RE: 5 Dartmouth Square, Dublin 6.

I refer to the above property and to our application under s.5 of the Planning and Development Act 2000 for an exemption in respect of proposed works to our house.

The second element is that at number 5: "5 Re-landscaping the front garden, without making any changes or works to the existing railings; to provide a gently sloping path to the lower ground level for baby buggies and bicycles." This was refused an exemption. We seek to review this refusal.

**Partial Site Plan, Front Garden - PROPOSED**

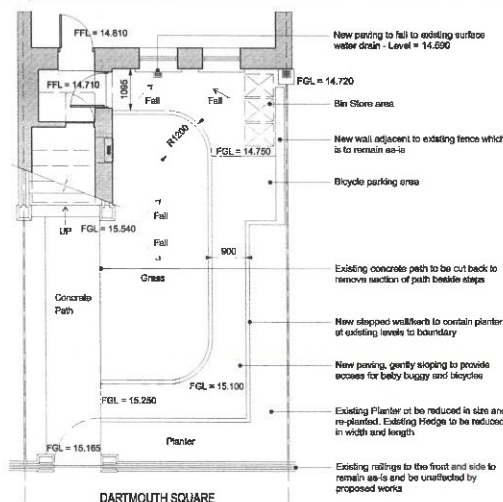
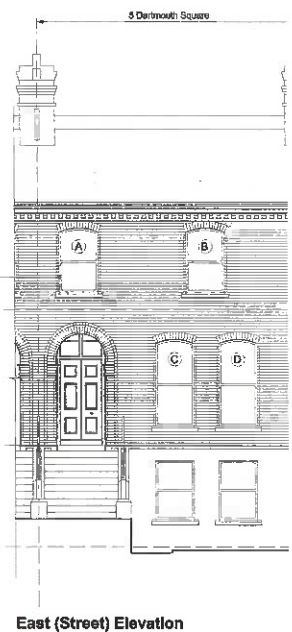
The proposed works are manifestly sympathetic with the house. They were specifically designed to be so. They are not radical. They are in fact a minor change. They are similar to others in neighbouring houses. But most importantly, they won't be seen. We do not plan to alter the front rails or current hedge. The height of same will ensure that most of the works cannot be seen from the street.

None of the works relevant to this review are to the structure as such. They are to the front garden. We cannot agree that they "materially" affect the "character" of the structure at all.

Partial Site Plan, Front Garden - PROPOSED

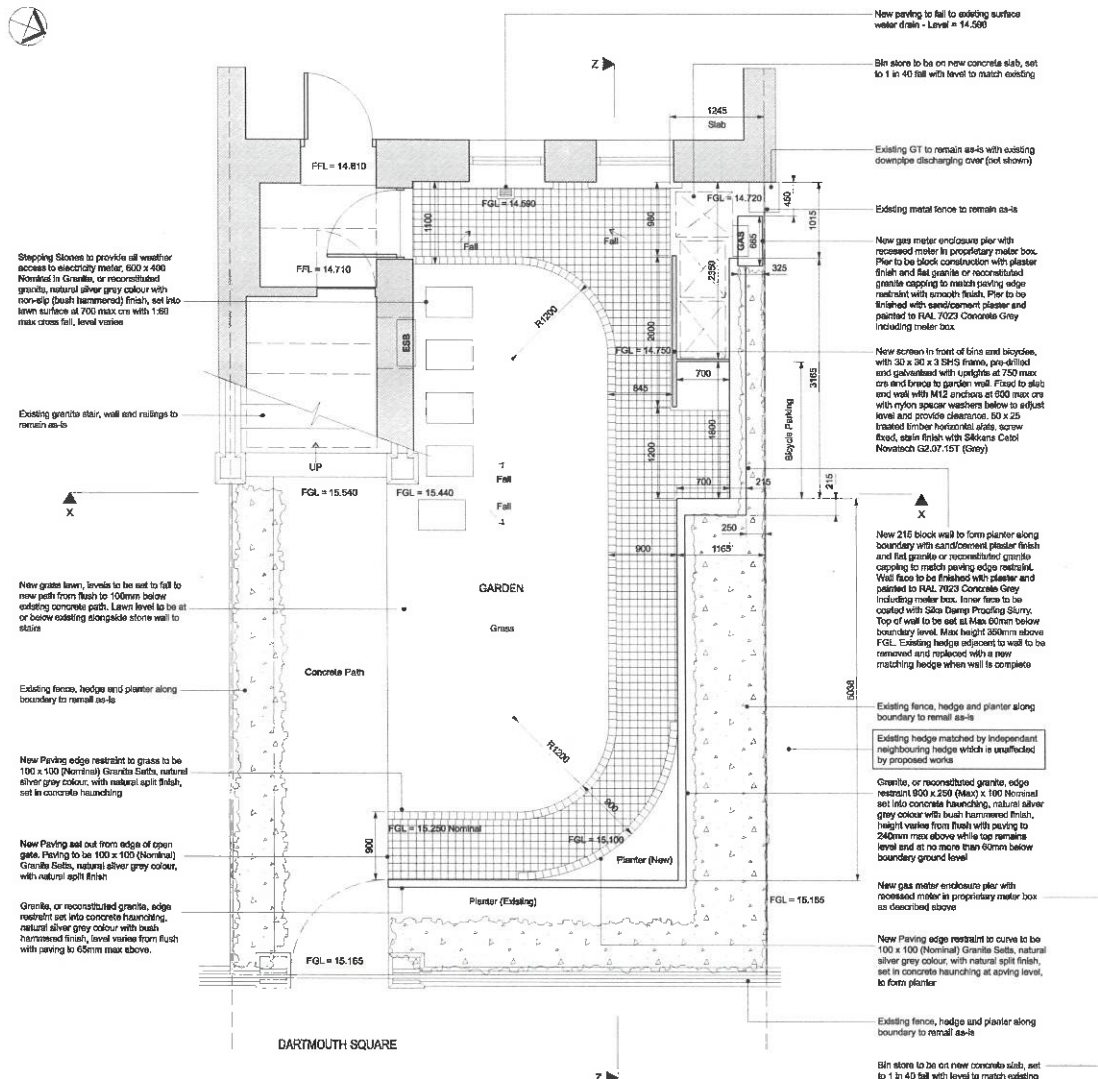
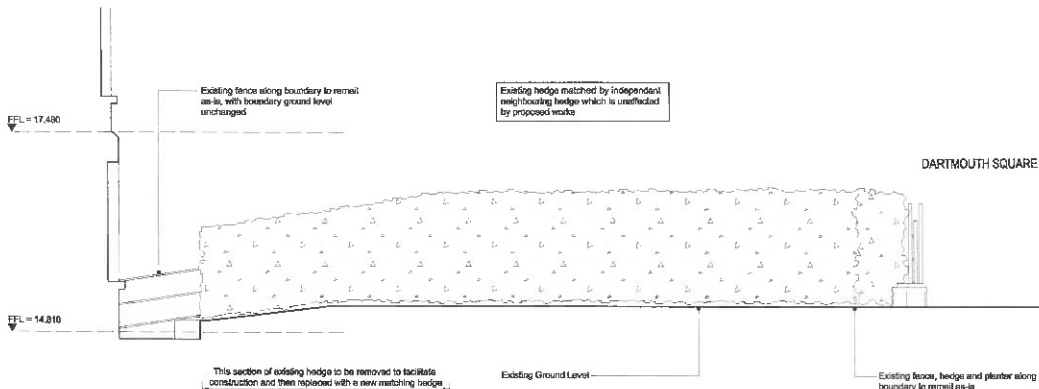
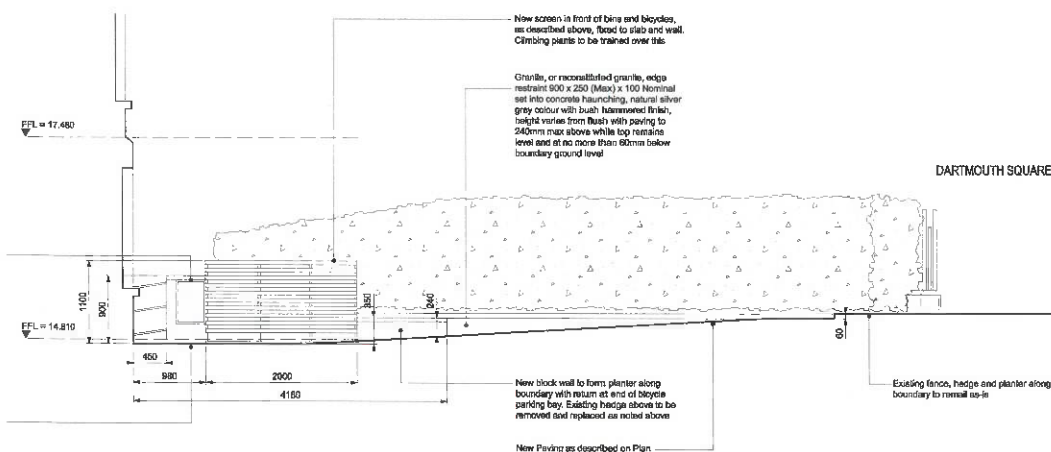
The applicant is requested to provide details on the height/depth/length of the proposed wall along the northern boundary, an elevation drawing showing its height in relation to the front façade of the house and the material to be used in its construction. This information is to include any proposal for a perpendicular wall at its eastern end.

The applicant is requested to provide section drawings showing the alteration to the slope of the garden across both the grass and the new path to assess whether this will have an impact on the protected structure, particularly within the context of the surrounding gardens. These should be dimensioned so that the impact can be fully assessed.

The applicant is requested to submit full details on the colour texture and nature of the material to be used for the path in order for the impact of this on the protected structure to be assessed.

- *Details on the height/depth/length of the proposed wall along the northern boundary* – Heights, depths and length are noted and comprehensively dimensioned on the drawings. Note that the wall is at least 250mm from the existing boundary fence and the top of the wall is no more than 350mm above finished ground level and typically 60mm below the ground level at the boundary.

- *An elevation drawing showing its height in relation to the front facade of the house and the material to be used in its construction* – Sections x-x and y-y on the drawings include elevations that show the proposed low wall in relation to the front facade of the house, and the construction is noted on the Plan

- *This information is to include any proposal for a perpendicular wall at its eastern end* – The wall is only 3380mm long and there's a short return 700mm long at the eastern end and this is 240mm above finished ground level and typically 60mm below the ground level at the boundary.

- *Provide section drawings showing the alteration to the slope of the garden across both the grass and the new path and these should be dimensioned* – Two sections labelled x-x and y-y are provided and both are dimensioned

- *Submit full details on the colour texture and nature of the material to be used for the path* – The Paving material for the path is to be 100 x 100 (Nominal) Granite Setts, natural silver grey colour, with natural split finish
